RE: Staff Review Comments for 343 Forest Avenue – Liberty Bay Recovery Center (2017-086)
– Planning Authority Review

Project Name:	Liberty Bay Recovery Center	Project ID:	(2017-086)
Project Address:	343 Forest Avenue	CBL:	112-D004
Applicant:	Nathan Cermelt		
Planner:	Matthew Grooms

Final Plan for Planning Board Review: Staff Review Comments

COURTYARD PLAN

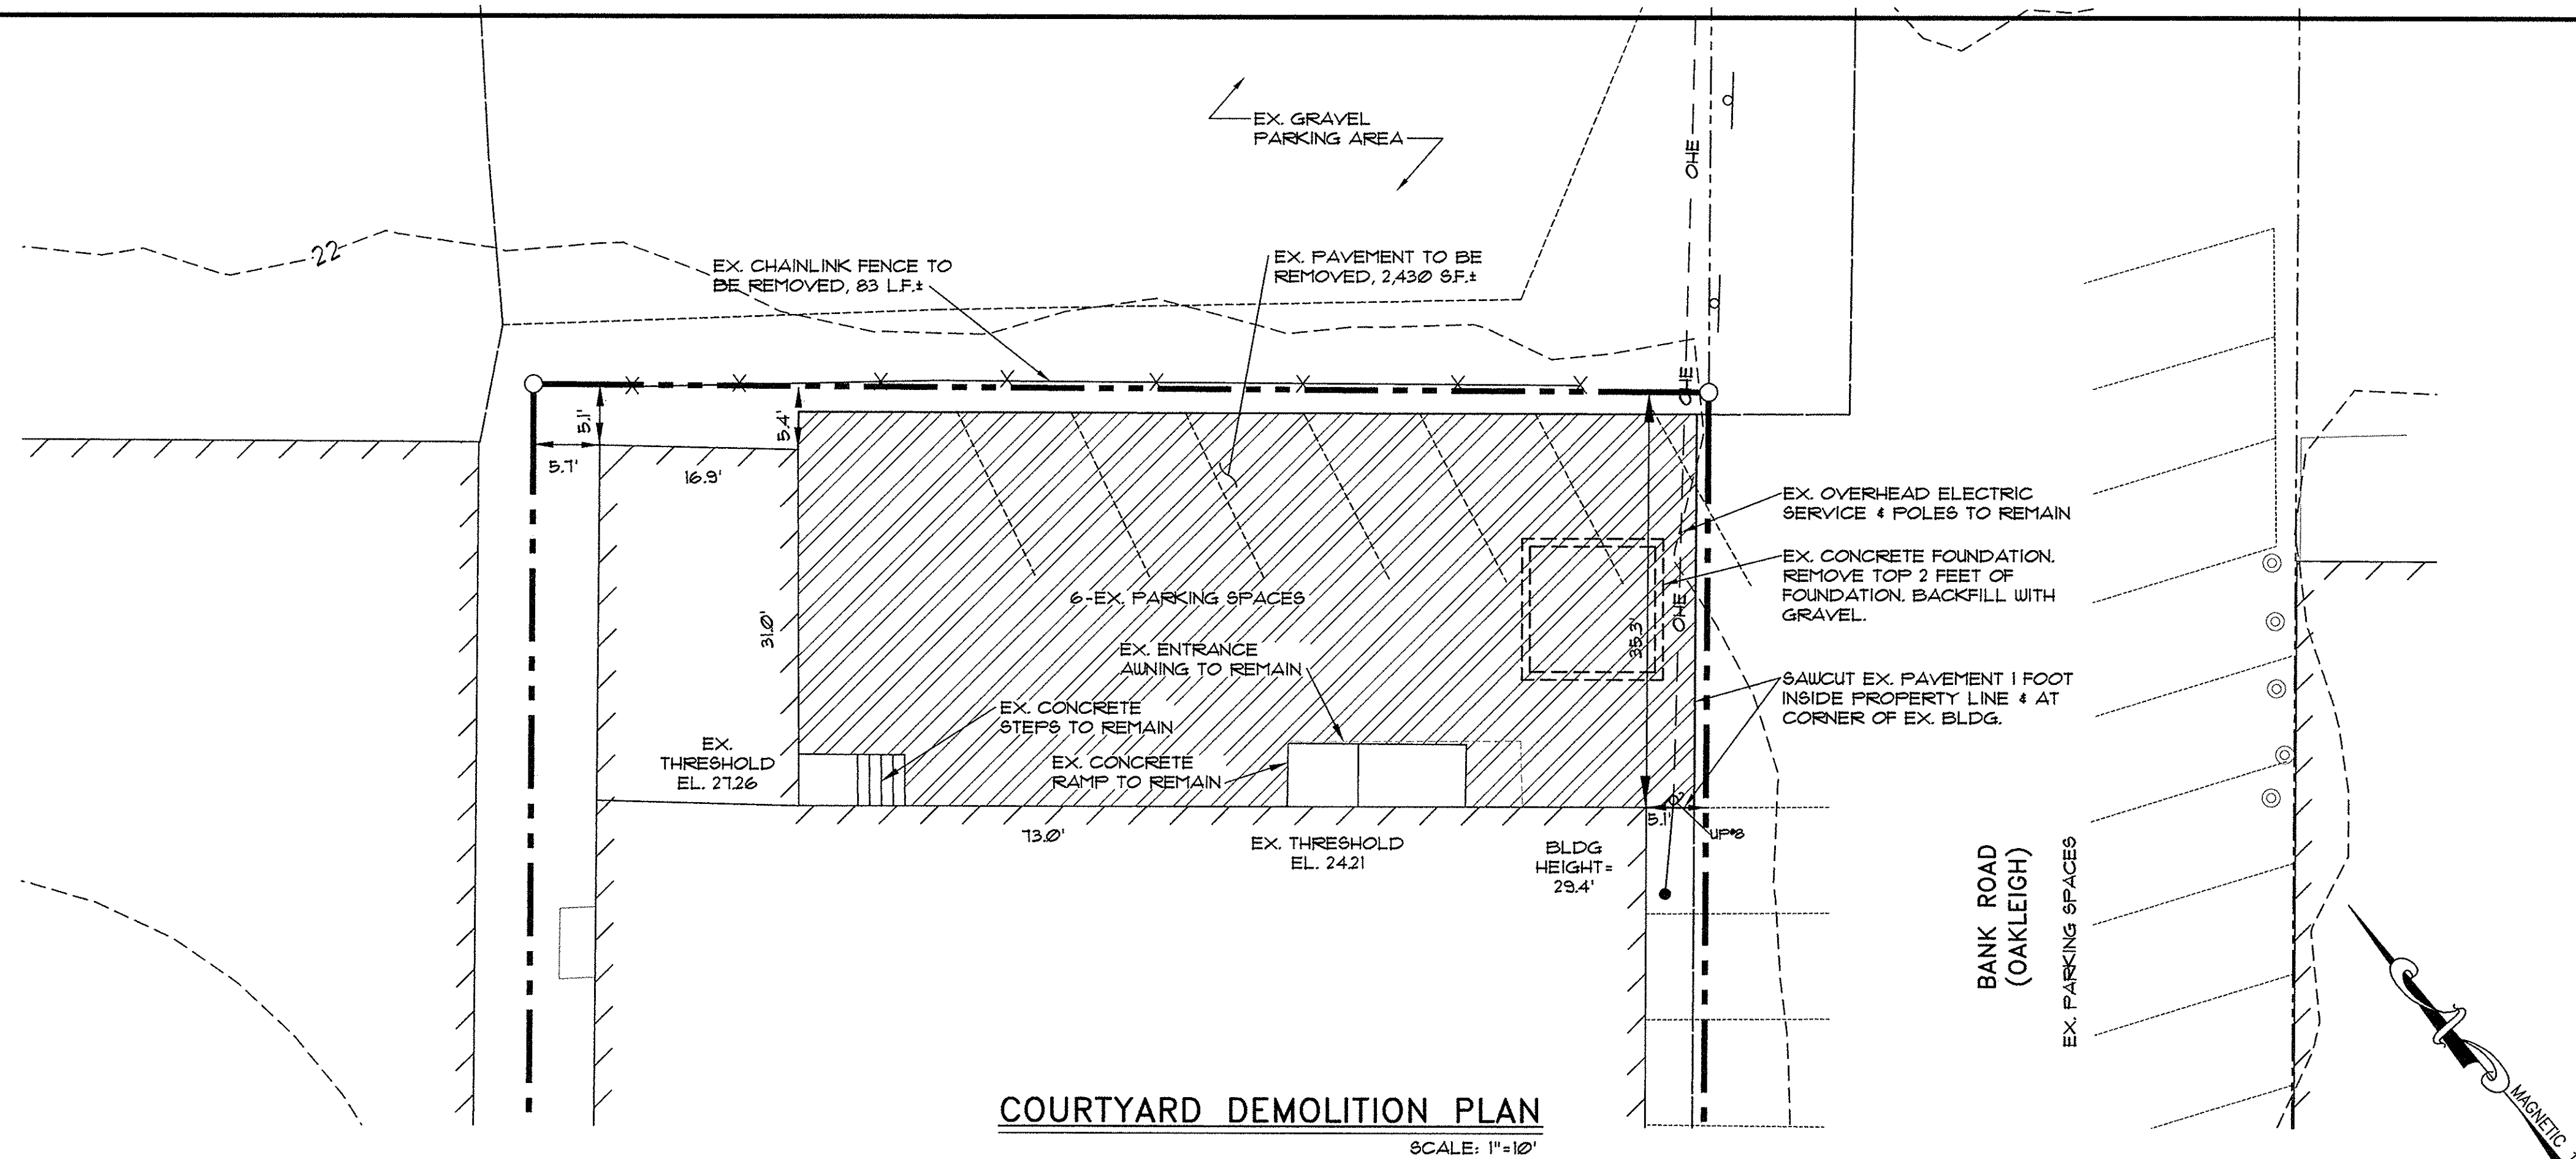
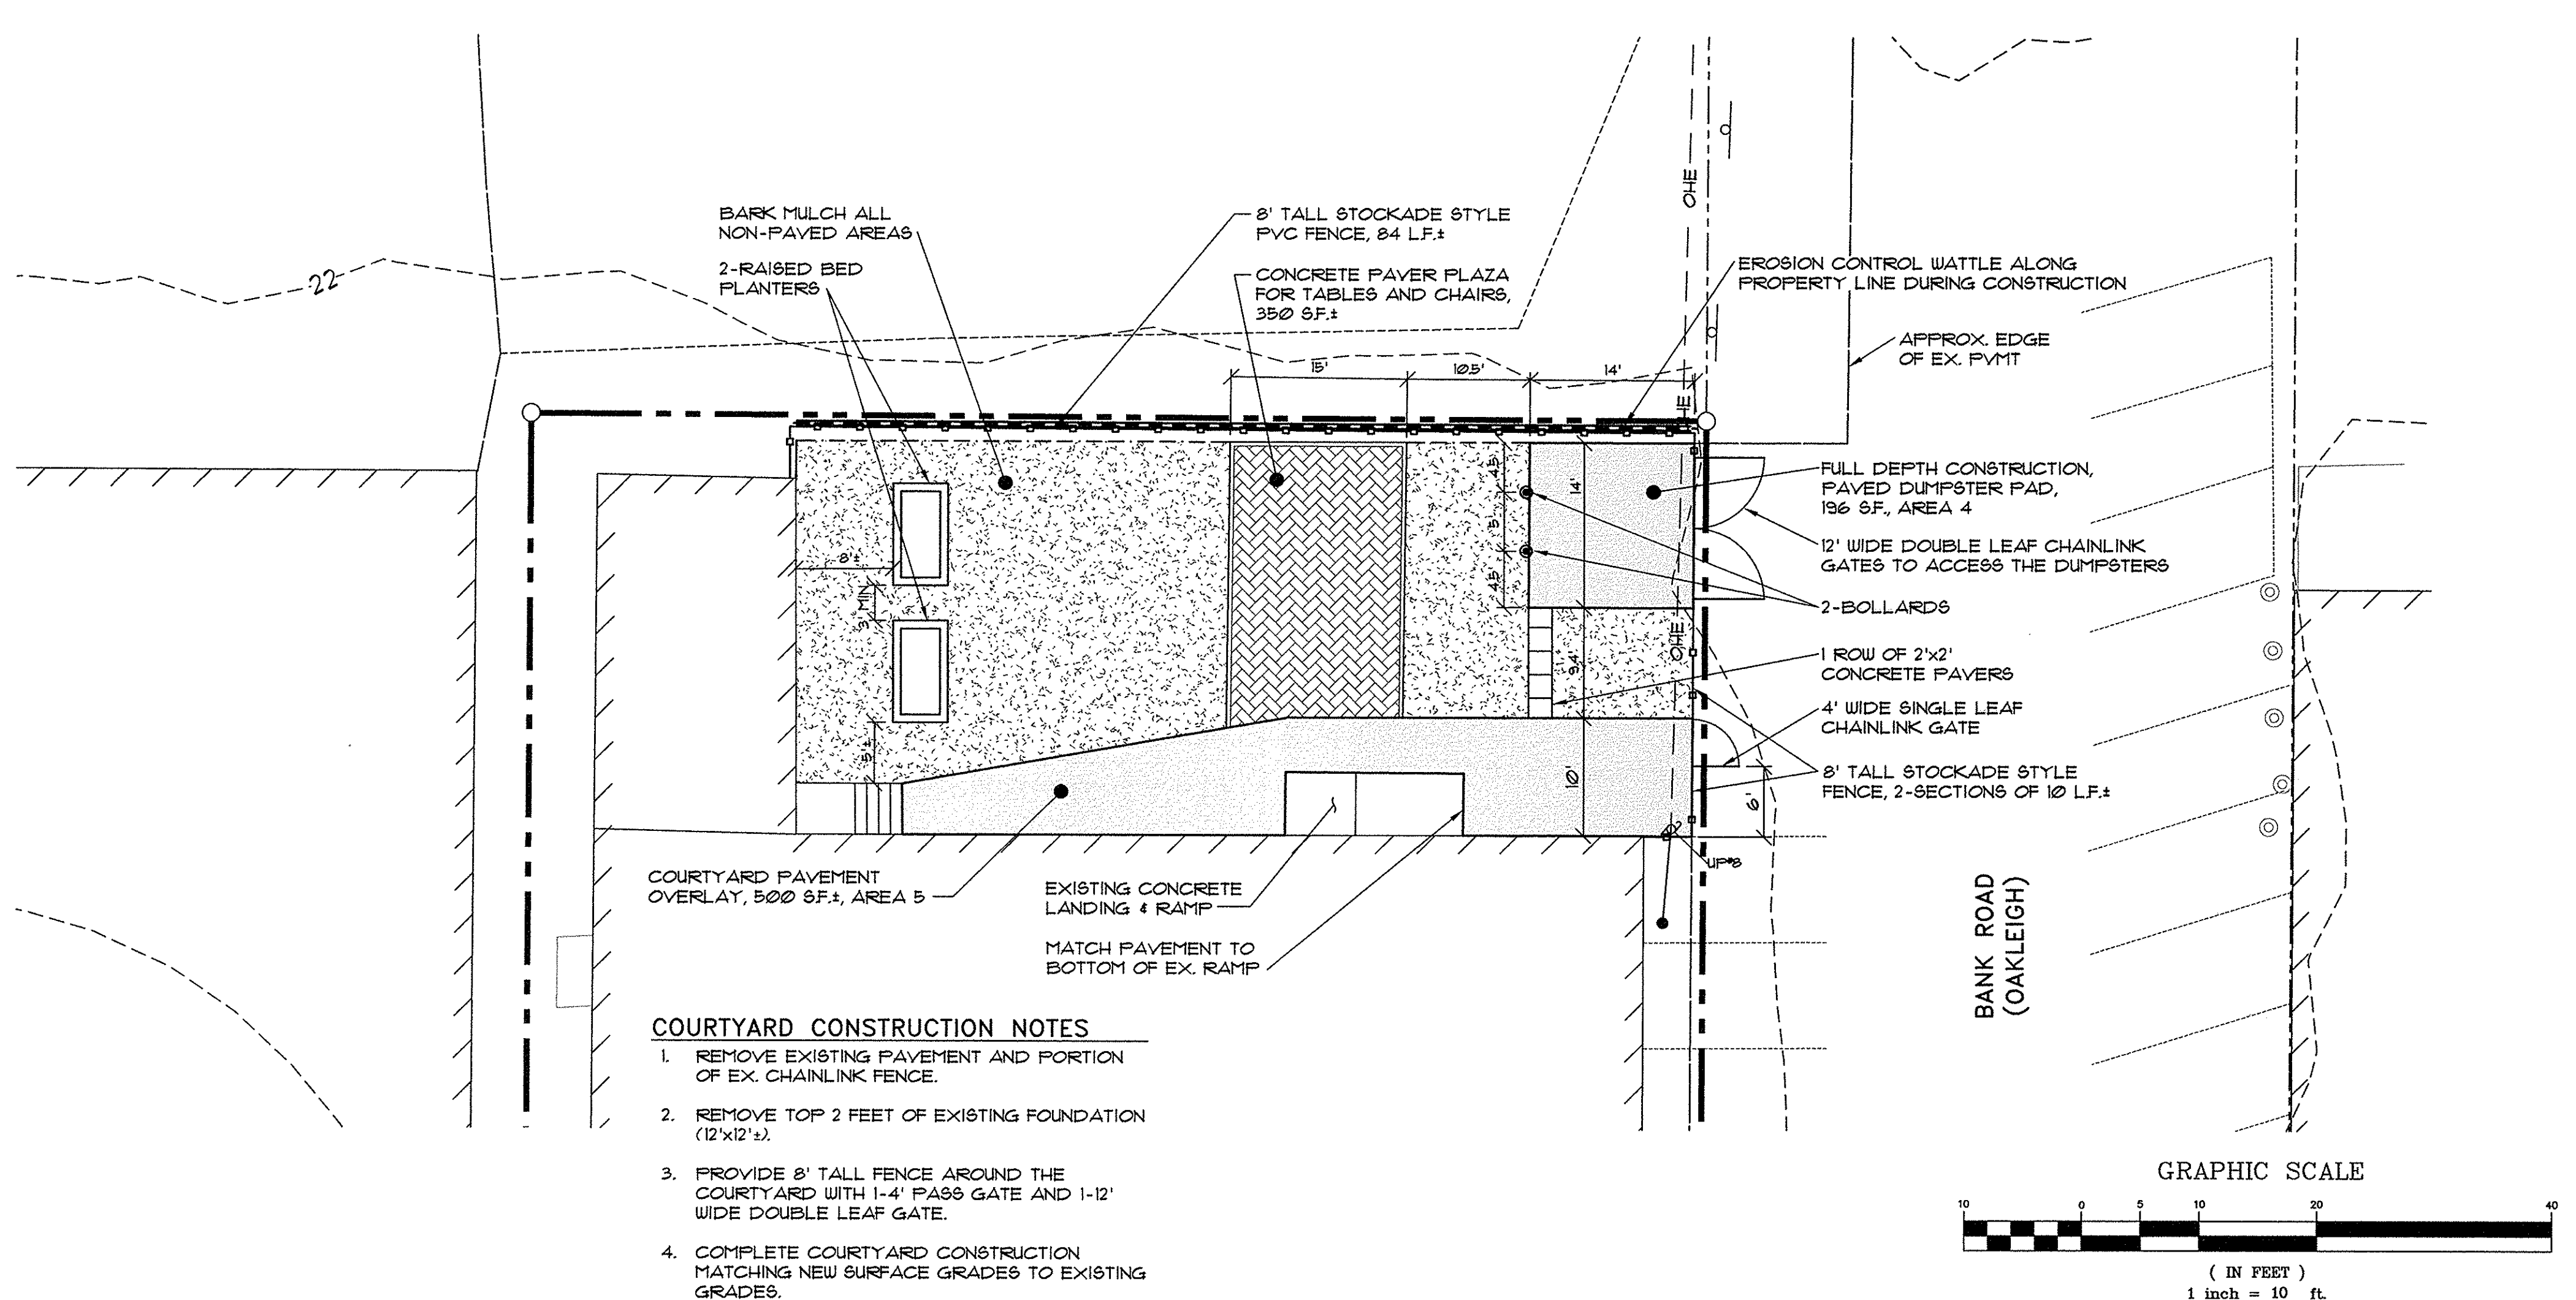
7. Of the parking spaces shown, which are allotted for this particular user? This should be clearly delineated within the submitted plans.
8. Please indicate the proposed use for the gravel parking area immediately to the rear of the building at 343 Forest Avenue? The plans do not indicate any site work at this location. Will these parking spaces be available for use by employees/visitors to this facility, or is this parking area being utilized by another user? Please explain.

9. How will solid waste be managed on site? It appears that there is a dumpster enclosure to the rear of the building being proposed. Please note that waste receptacles shall be screened in full compliance with Site Plan standards as found under Section. 14-526.

10. Given the visibility of the rear parking area, would the applicant consider the installation of additional vegetation/landscaping adjacent to these parking spaces?
